Noise Assessment Report

Noise Impact Assessment

Site: Proposed Data Cabins

Redbrook Business Park, Barnsley, S75 1JN

Drawn by VV	Checked by SB	Approved by JR
Date Drawn 01.05.20	Date Checked 01.05.20	Date Approved 01.05.20
Site Region -	Drawing Number P1808-139-PL-004-D

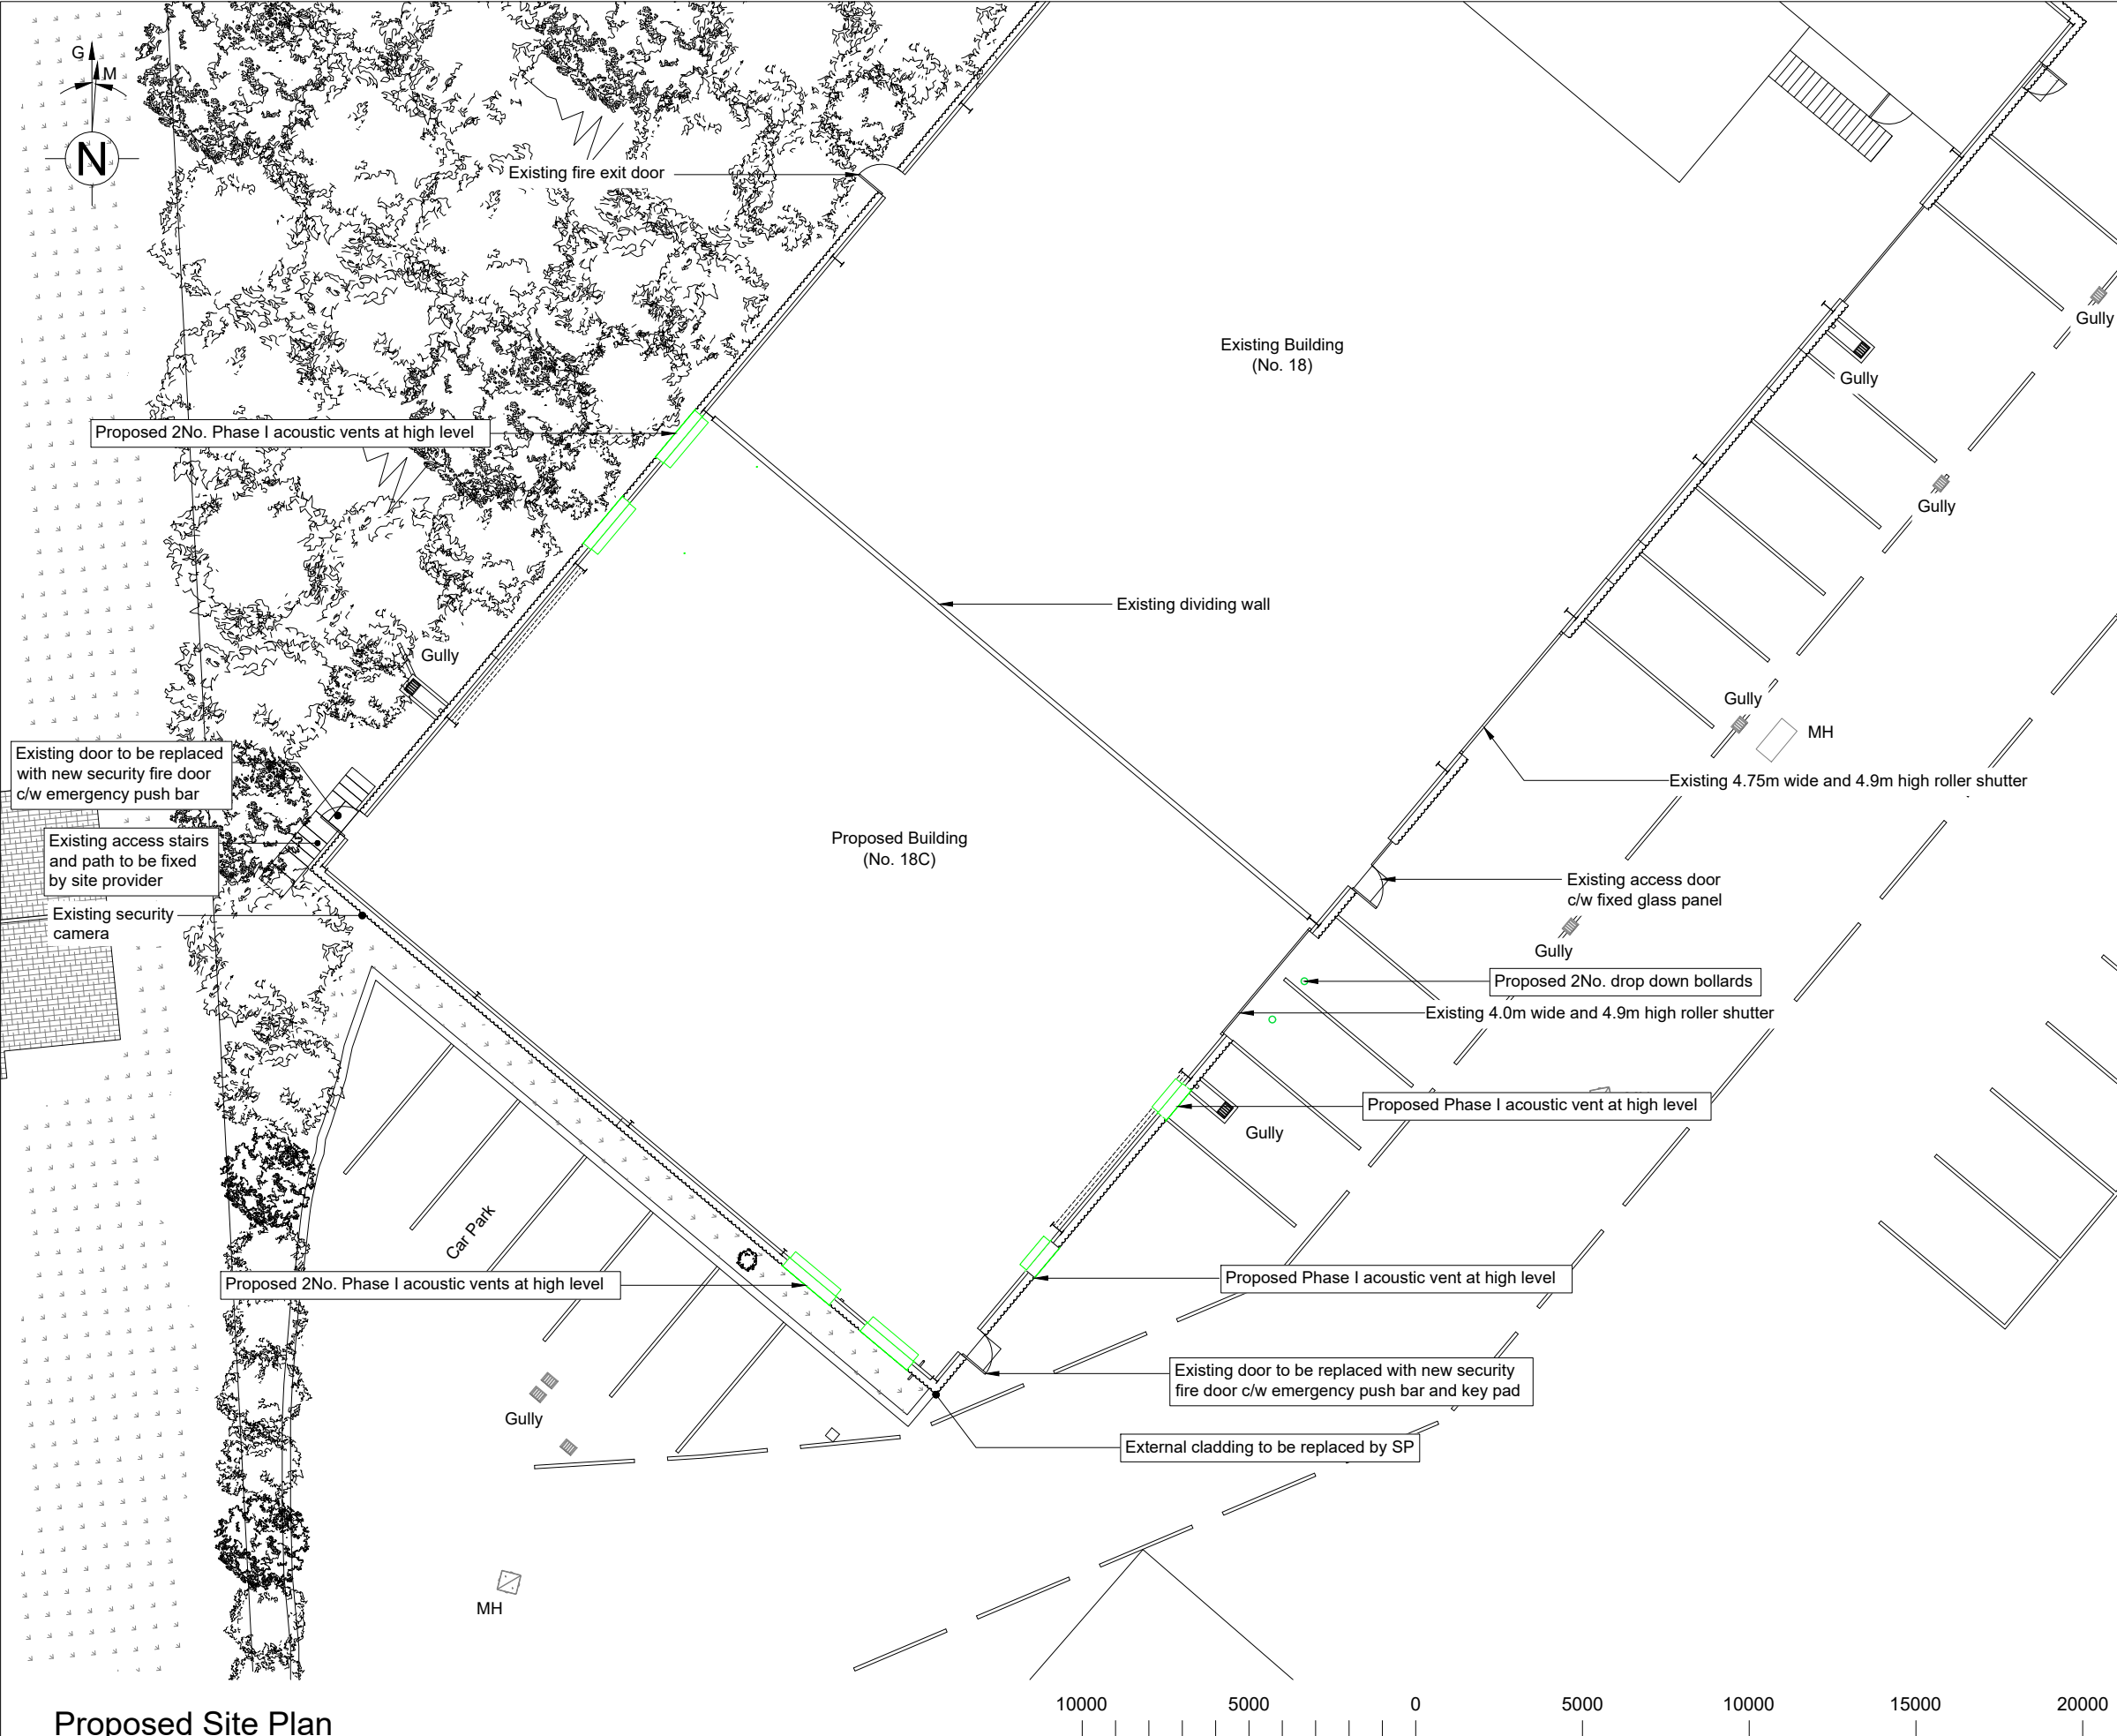
13.2 Below, in Figure 3, is the proposed relocation of plant.

- 13.5 The newly proposed generator position to the South East façade would result in a fully blocked line of sight between the generator exhaust vents and the receiver.

- 13.6 The mitigated noise rating level when considering all plant running simultaneously is calculated at 48 dBA, improving on the original level significantly but still exceeding the Background Sound Level by 16 dB. Therefore, further mitigation is required.

- 14.1 All plant vents located on external façades would need to be acoustically louvred. An acoustic louvre for each plant vent should have a minimum attenuation factor of **21 Rw** (weighted sound reduction index). Table 8 shows the minimum Sound Reduction Index required.

Drawn by VV	Checked by SB	Approved by JR
Date Drawn 01.05.20	Date Checked 01.05.20	Date Approved 01.05.20
Site Region -	Drawing Number P1808-139-PL-004-B

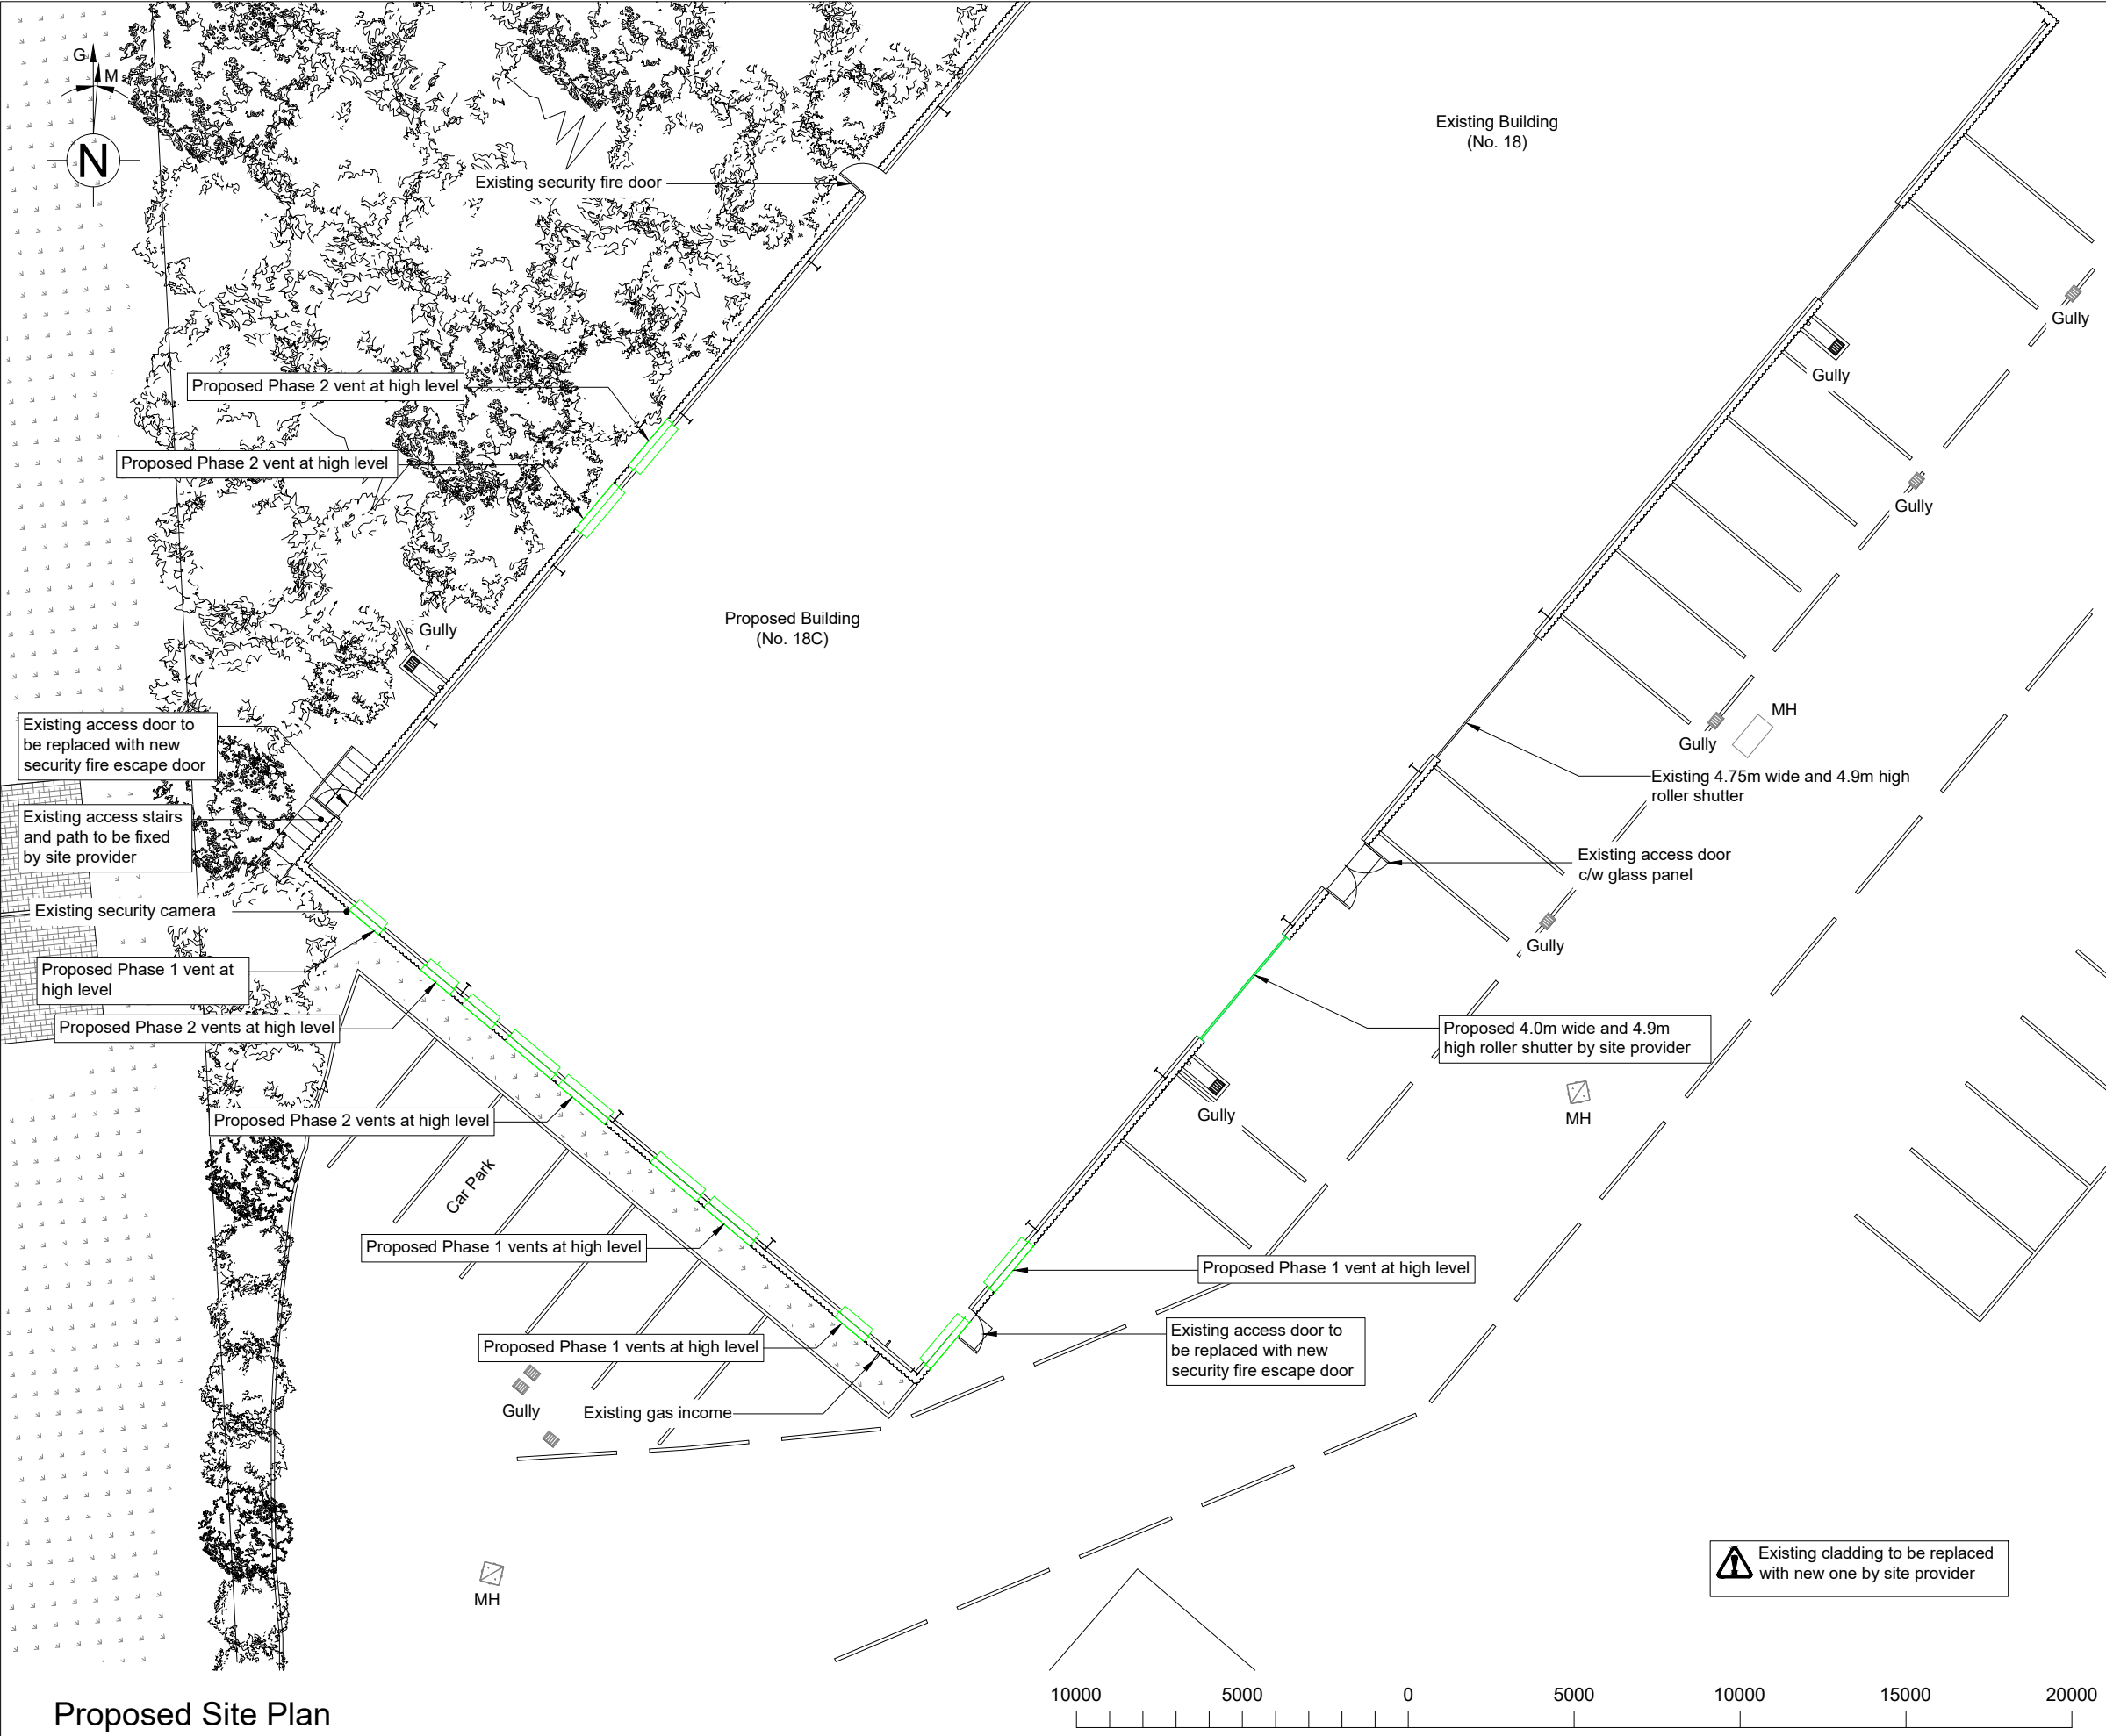
13.1 The latest floor plans, provided by the client, indicate that all plant vents are to be installed on the South West façade of the site, facing toward the NSR dwelling. This can be seen in Figure 2 below.

- 13.3 Relocating all AC units would result in a revised noise rating level of 43 dBA at the NSR. Although this is an improvement, the predicted level still exceeds the background sound level by 11 dB.

- 13.4 The Rating Level for the AC plant at the NSR location is 11 dB above the lowest background sound level; indicative of a *Significant Adverse Impact* in accordance with BS4142:2014. Therefore, further mitigation is required.
